DEVELOPMENT REVIEW BOARD
SUPPLEMENTAL SUBMITTAL

PROJECT NO. PR-2019-002598
Application No. SD-2022-00146

November 11, 2022

Re: Final Plat Review for Proposed Lots J-1 and J-2 of Vista de la Luz, being comprised of Lot J, Vista de la Luz

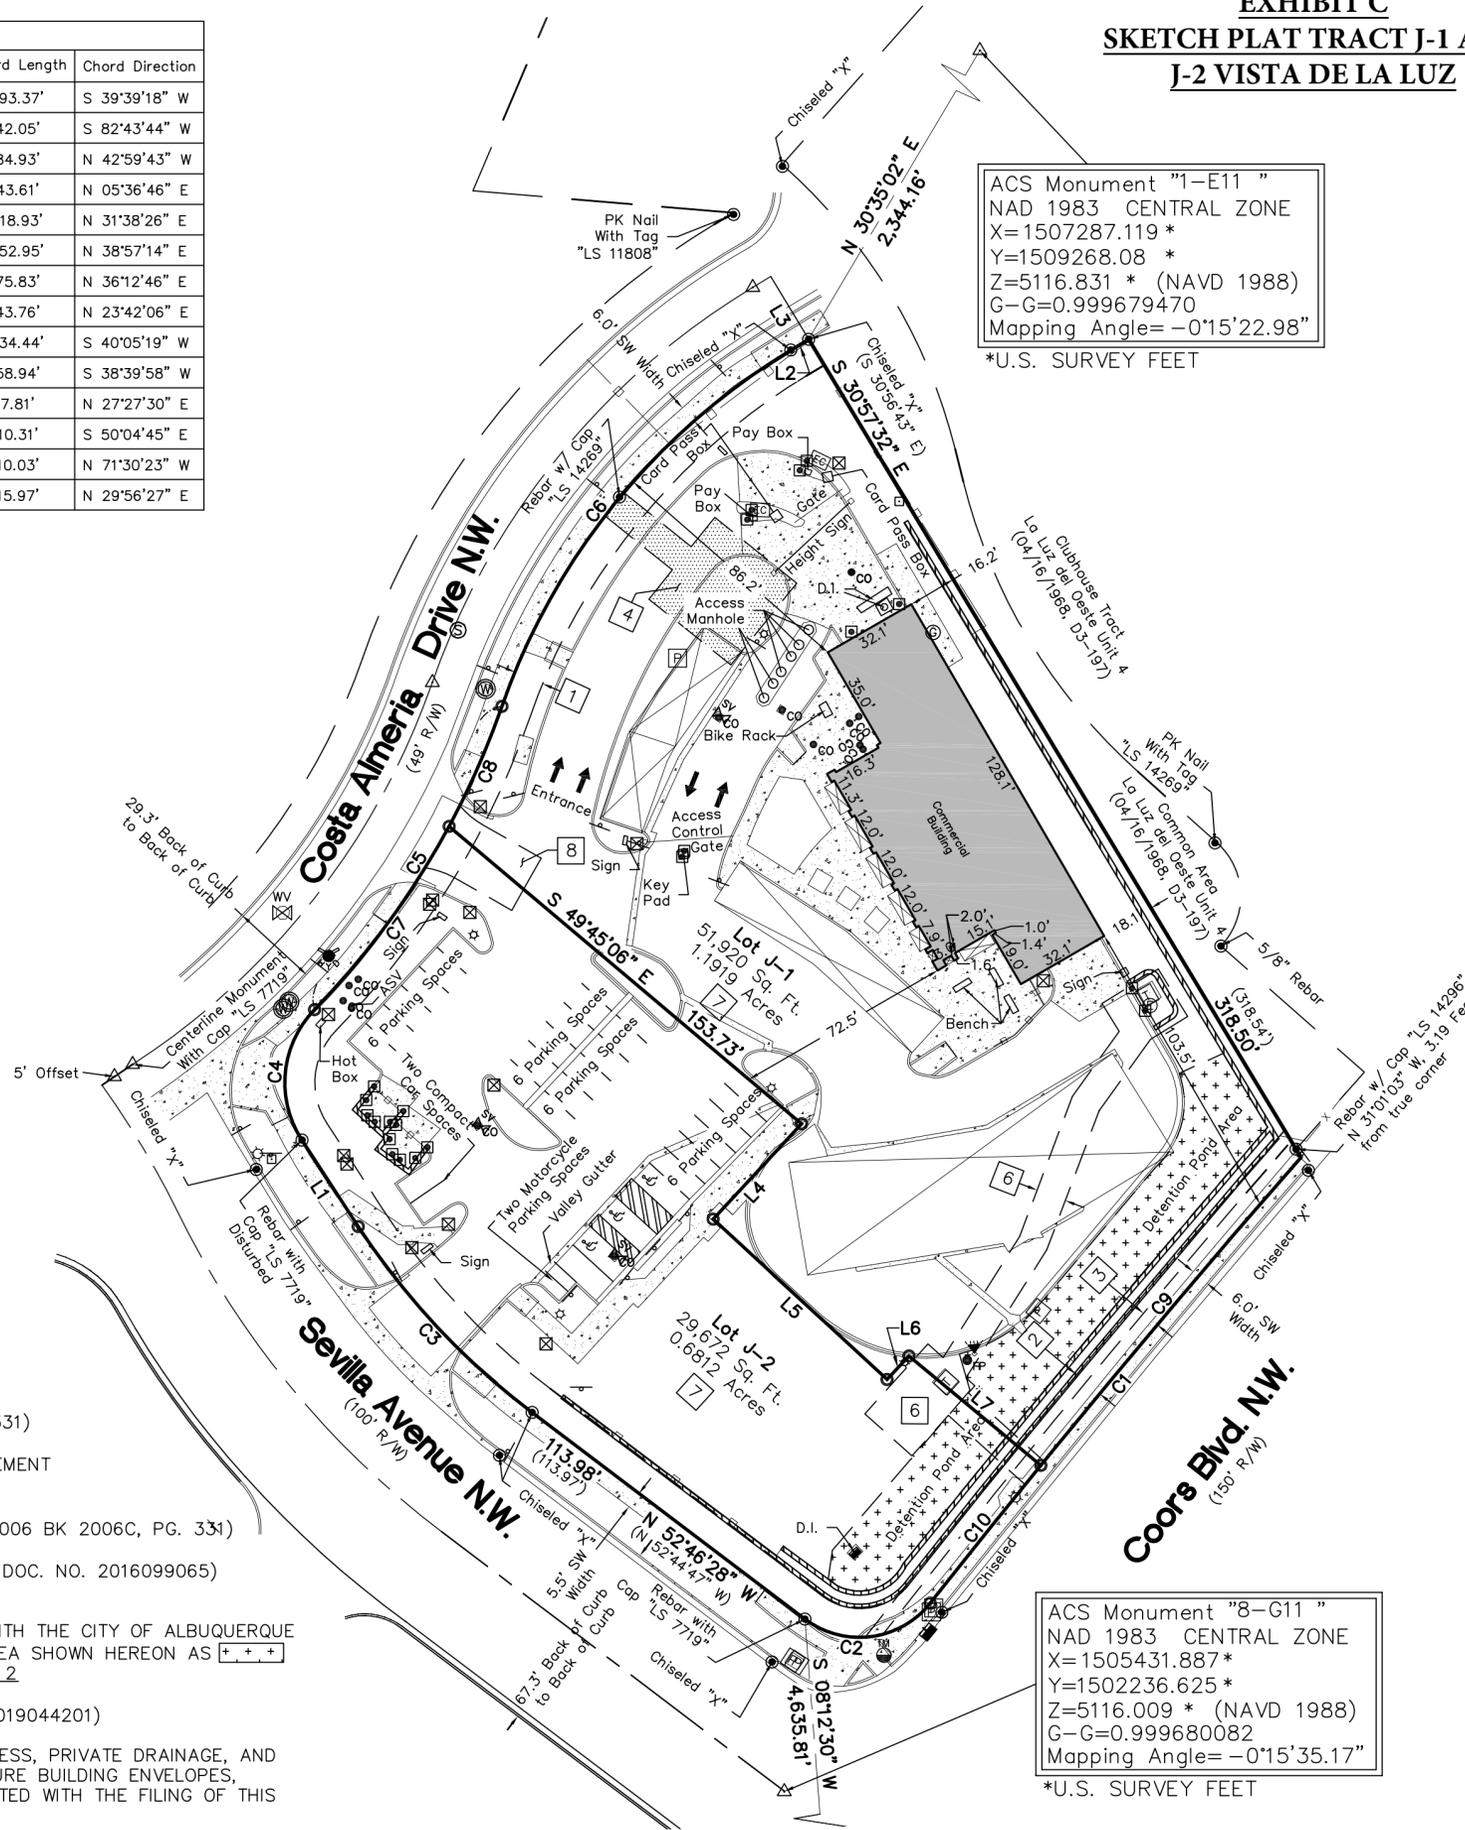
3. Dimensional Standards for setbacks must be provided from the EPC approved Subdivision Plan and/or prior approved DRB Site Plan, in order to verify if structures will meet setback requirements with new lot lines.

Noted, new dimensional labels have been added to the covered area on Lot J-1, where concern for setbacks from proposed L4 boundary line may have been present. Administrative amendment to site plan will similarly address setbacks.
